From: Richard Temple
Sent: 24 January 2018 16:29
To: Planning.Responses
Subject: FW: Ref Planning Application FP/268/17/PL

Richard Temple | Senior Planning Officer, Directorate of Place, Arun District Council | Location: Phoenix House, Arun Civic Centre, Maltravers Road, Littlehampton, BN17 5LF

Subject: Ref Planning Application FP/268/17/PL

Timber Planks to be fixed without gaps, to the timber posts, sitting on top of the existing seawall.

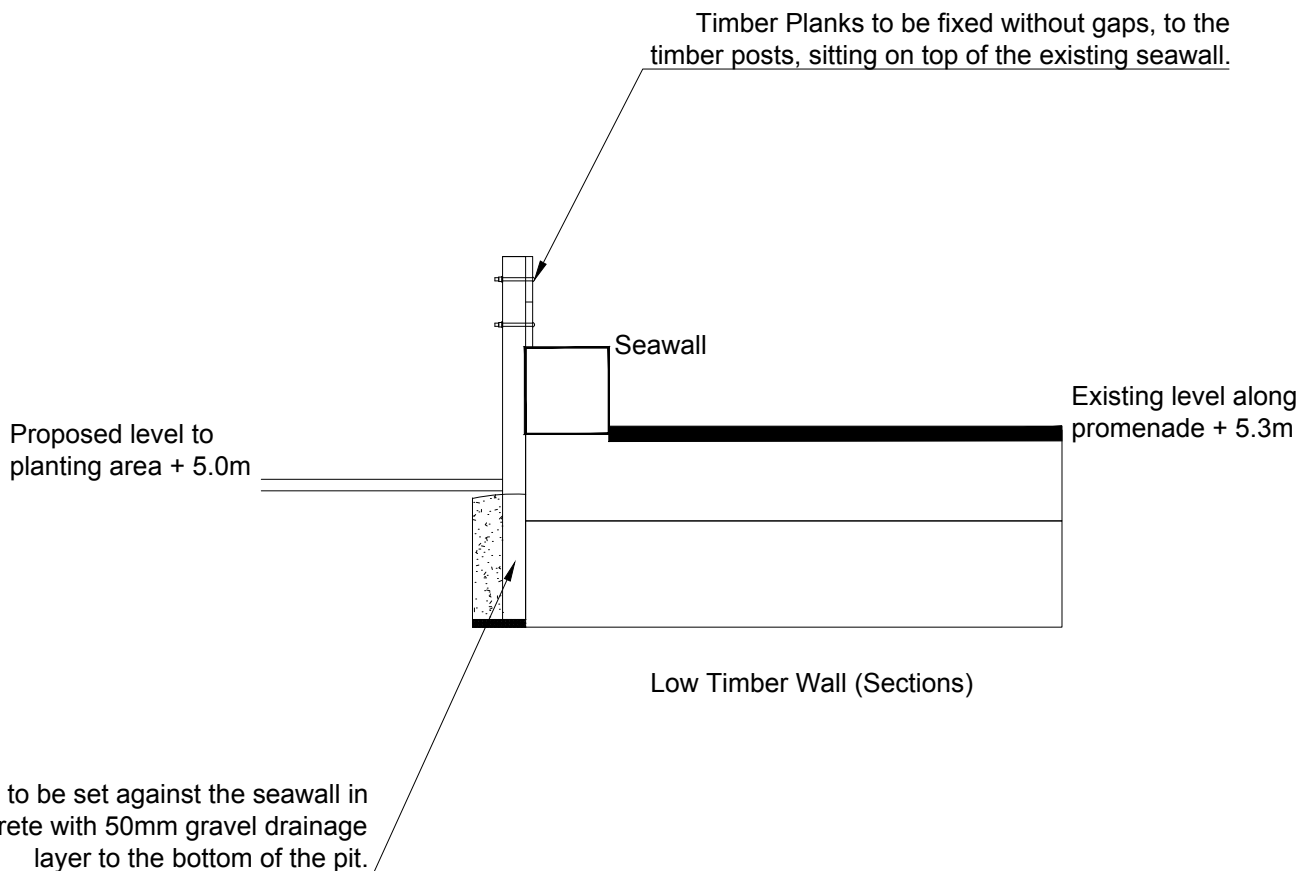
However, I would urge you to change the min 1500mm centres to "max"

I would also suggest that you reconsider the fixing detail. As it stands, with the fence tight up against the back of the seawall, you wouldn't be able to fix the planks to the posts - suggest that you fix the posts against the wall then start the planks on top of the wall. You may have considered that we wouldn't like this encroachment over the seawall but I think it is preferable to your current detail. Sitting the bottom plank on top of the wall would also provide for a better seal too.

I assume that you'd concrete the posts into the ground, as I wouldn't want to put more loading onto our seawall by fixing into the back of it. Please also consider that digging out for the concreting in may be a little problematic - I'm not sure what the construction would have been in the 1960s when the seawall went in.

Thanks for your reply. We will take on board your advice. I will issue an amended drawing to you and Richard Temple tomorrow.
